Planning application a/158/18/pl

Variation of condition1 imposed under A/8/18PL relating to the substitution of approved plan drawings No ADC 962 04 rev A & 13 rev B for drawings No ADC 962 20 &21(ground & first floor plans & roof plans). This application affects the character & appearance of the Angmering Conservation Area,

Land rear of 1 to 6 The Cottrell,Angmering.

Ground Floor Plan @ 1:100

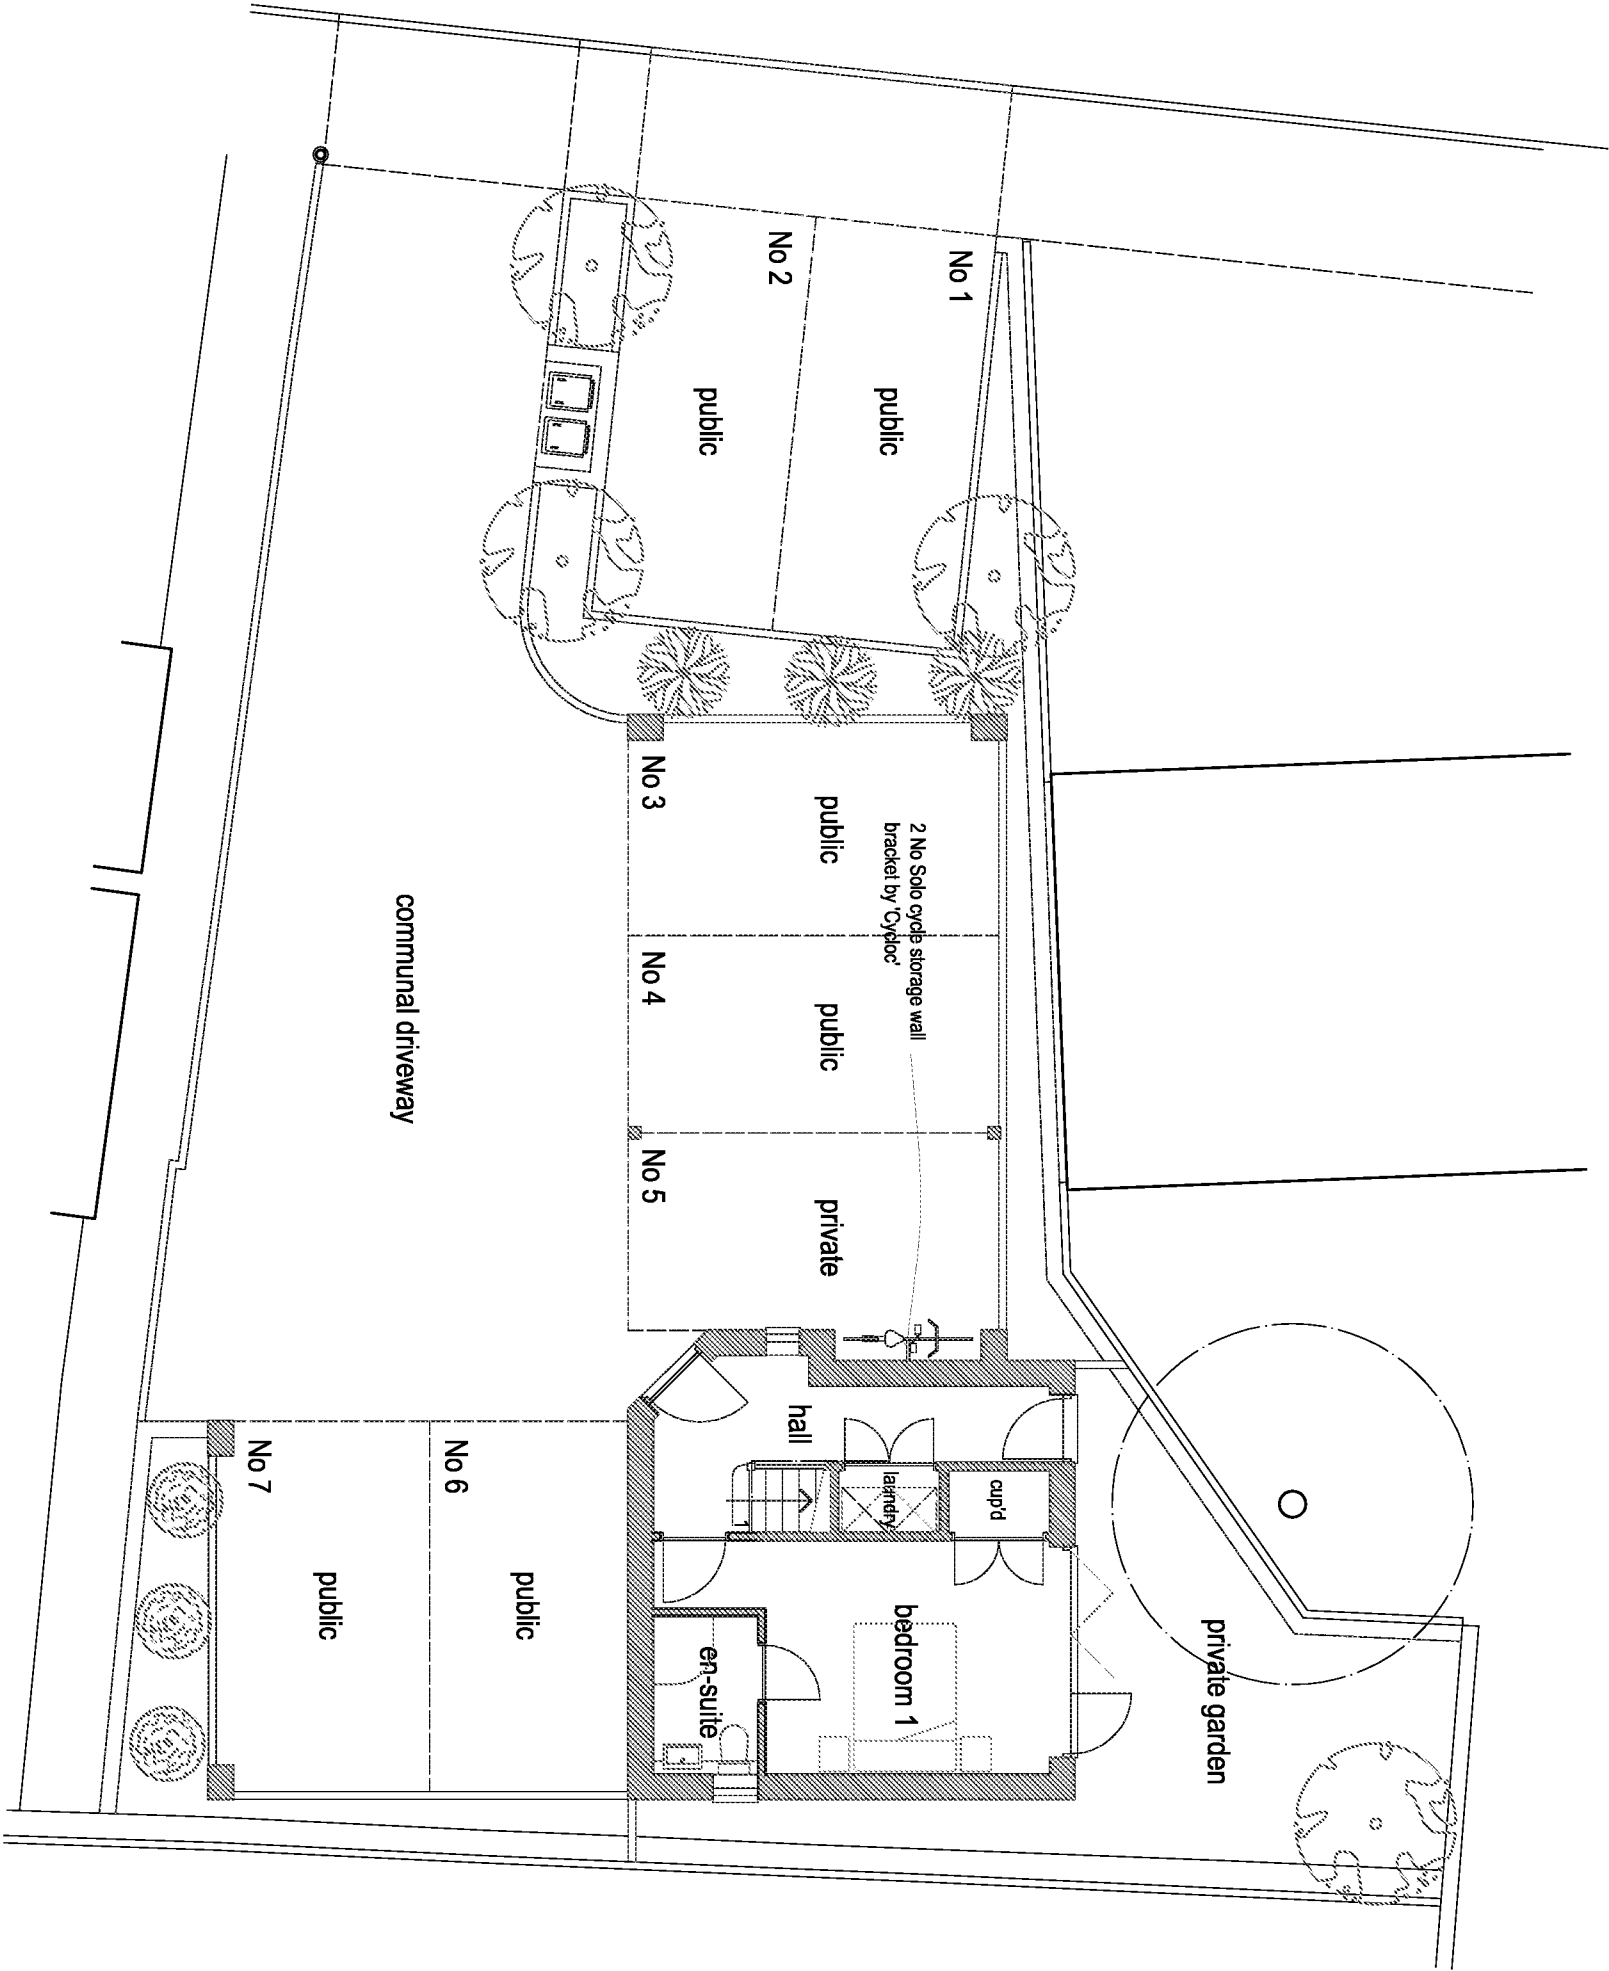
1/ Planning permission was initially granted for a 2 bedroom flat with downstairs garden/store/refuse/cycle room A/105/16/PL. The room was then changed to a kitchen/diner A/173/16/PL, but has actually been built with out planning with a master bedroom with en-suite downstairs, lounge/kitchen diner upstairs.In effect making it a three bedroom property

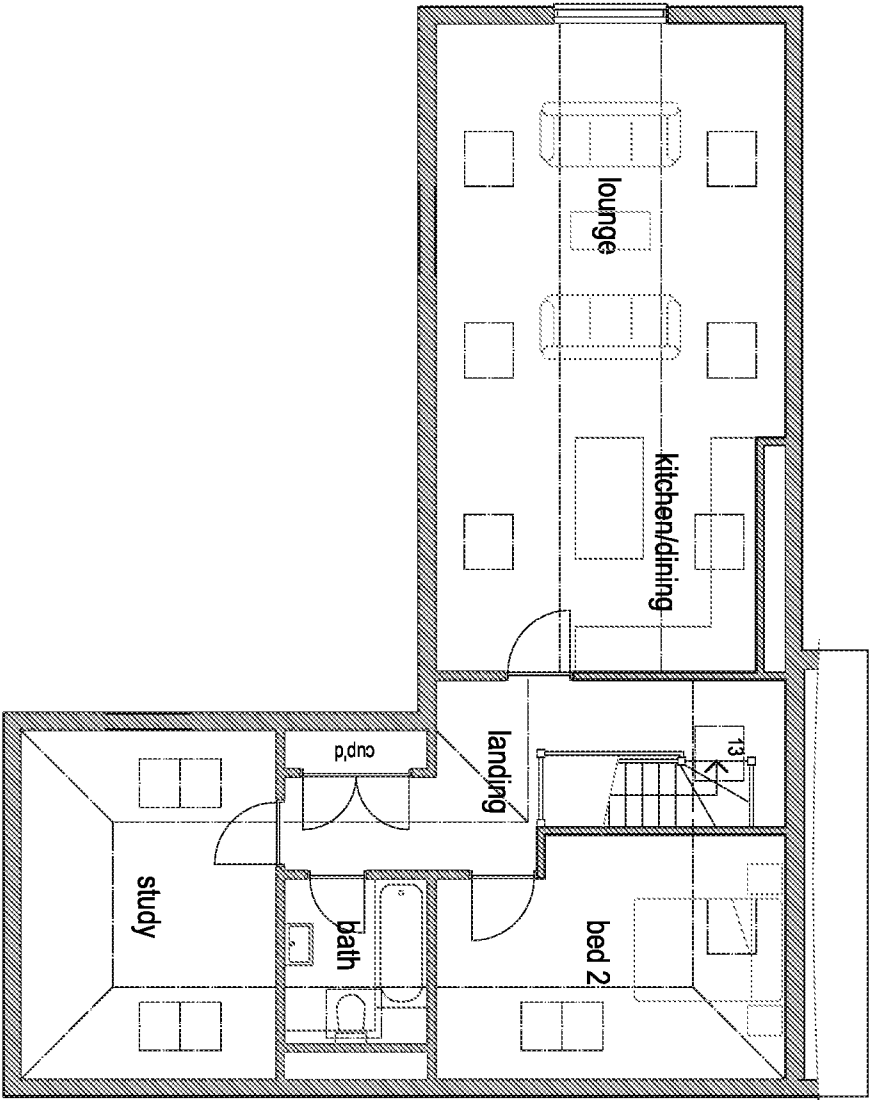
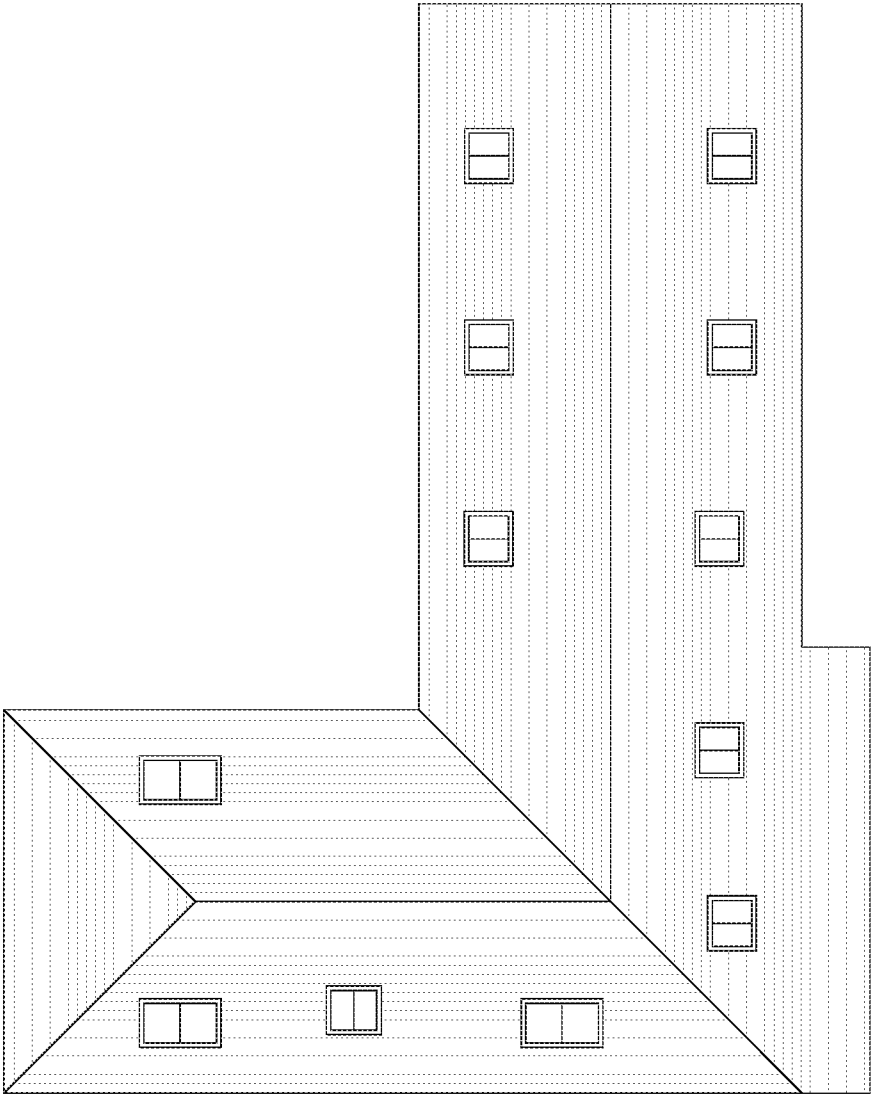
2/ Planning was given for emergency roof lights which have not been installed,showing complete disregard for the planning department and all health and safety requirements. It also shows he never intended on putting the kitchen diner downstairs which would have necessitated the safety windows upstairs.
